From: [REDACTED]
To: [Hinckley SRFI](#)
Subject: Comments on Tritax response to Secretary of State questions. Barbara Lees interested party number 20039334
Date: 06 February 2025 17:04:05

Having closely followed the proposal and made previous submissions I will address the specific issues raised by the Examiner in making the Decision to refuse this application, the response of your predecessor who was also minded to refuse the application and the response of Tritax to their points.

Aston Firs Technical Note
Appendix A (part 1)
Work No. 7 A47 Link Road
Acoustic Fence Location

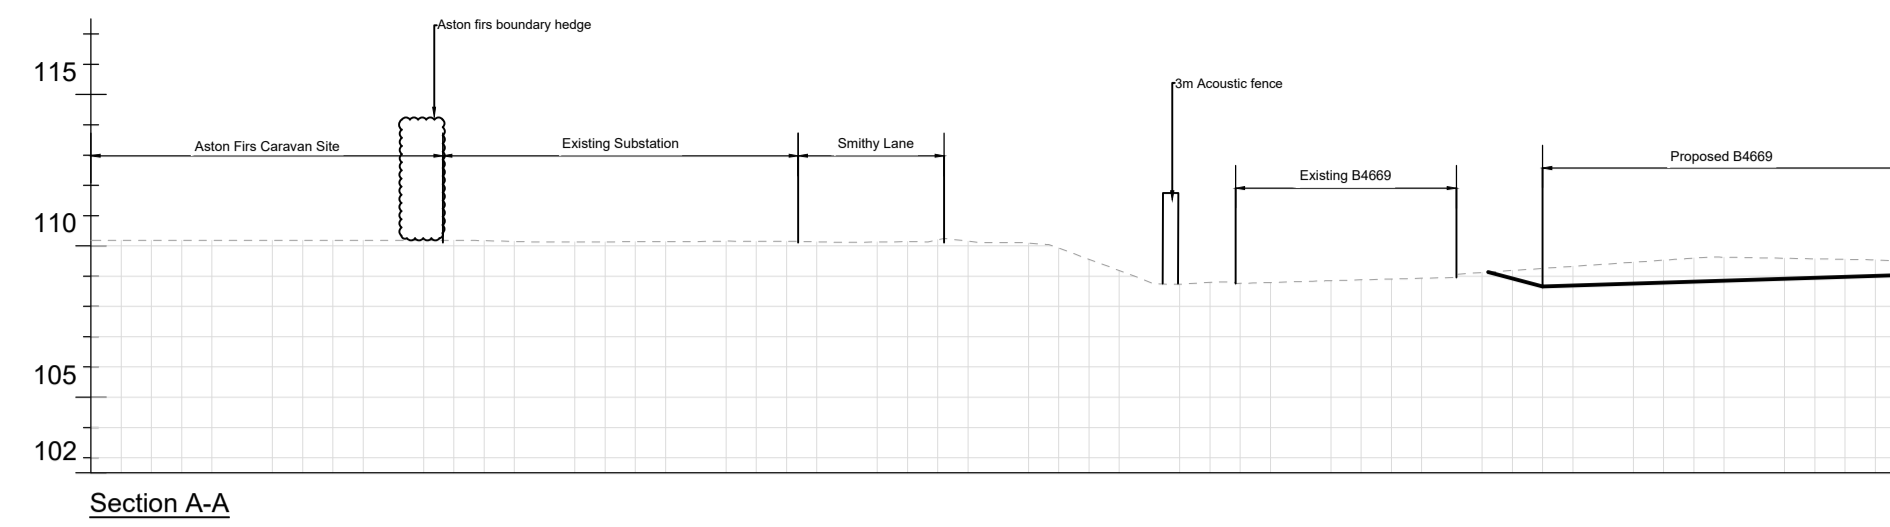
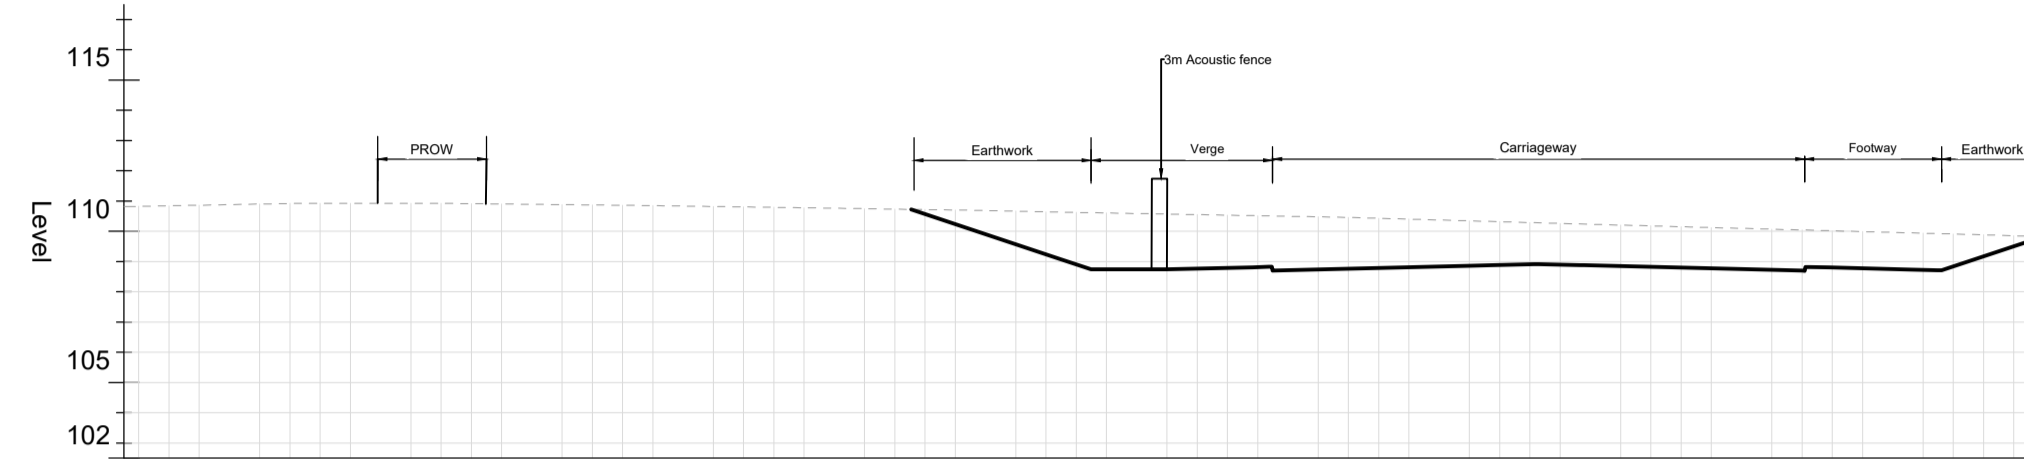
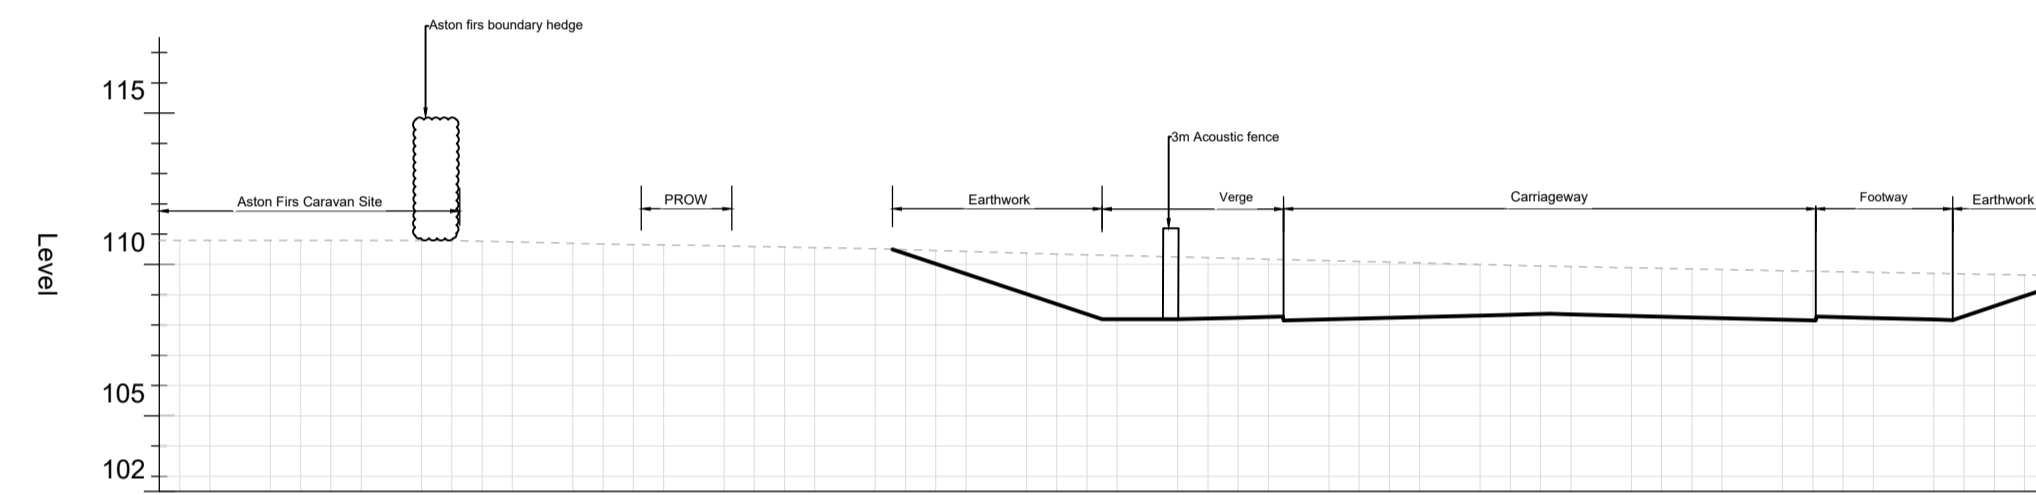
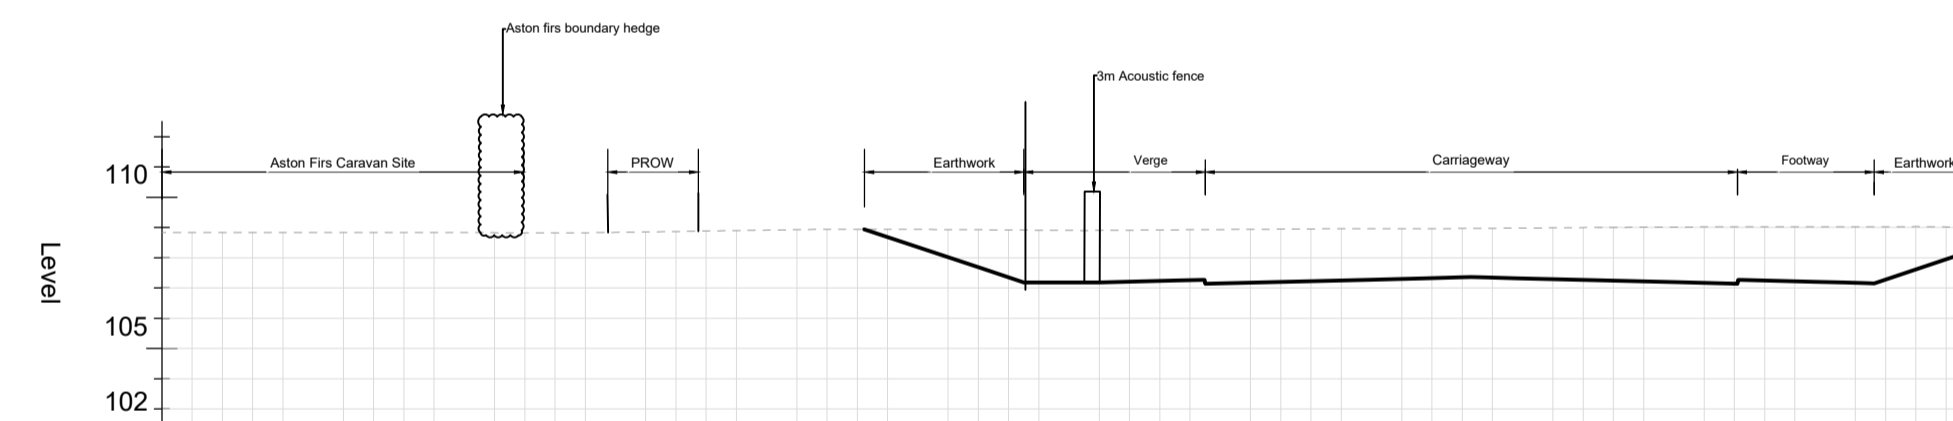
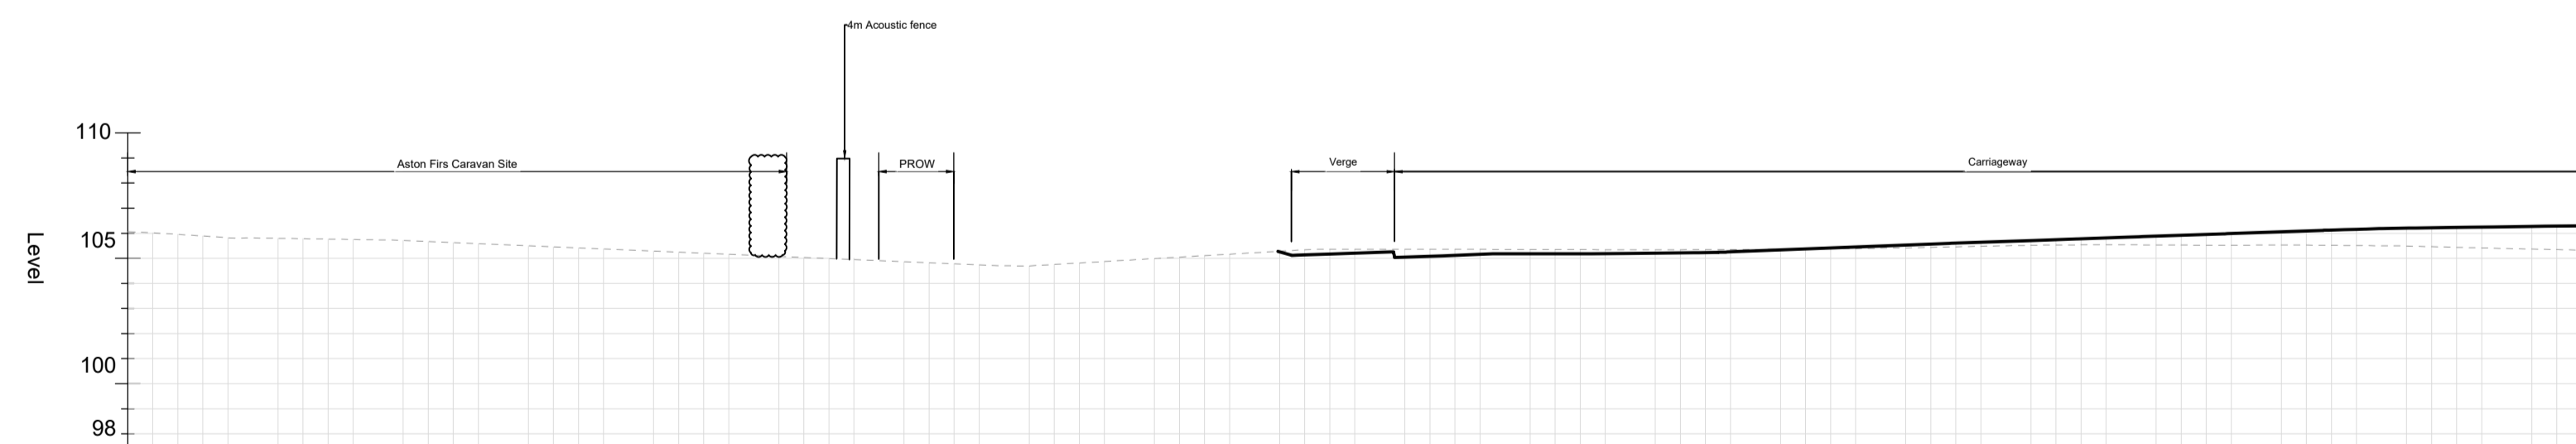
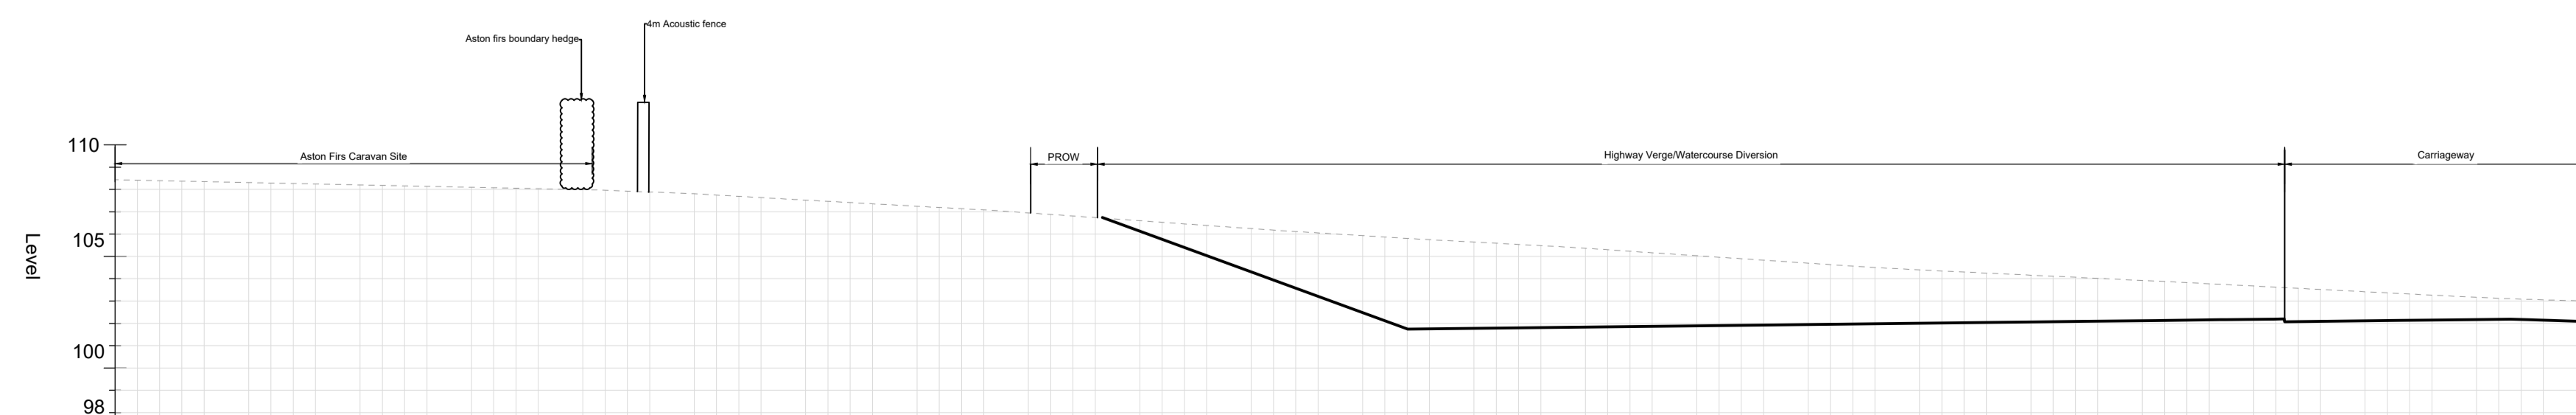
3. The impact of 24 hour noise on the traveller site and its mitigation with an intrusive acoustic barrier is not a humane solution. In addition to this there is no noise abatement solution for the town of Earl Shilton, the villages of Elmesthorpe, Barwell, Burbage, Stoney Stanton, Hinckley and Sapcote. The first three mentioned and the protected SSSI and leisure areas of Burbage Wood and Aston Firs will experience continuous noise from the gantry loading and unloading, container stacking, HGV movements, trains marshalled by hooter and trains slowing to enter and exit the site which will additionally be amplified by reflection from the warehouses.
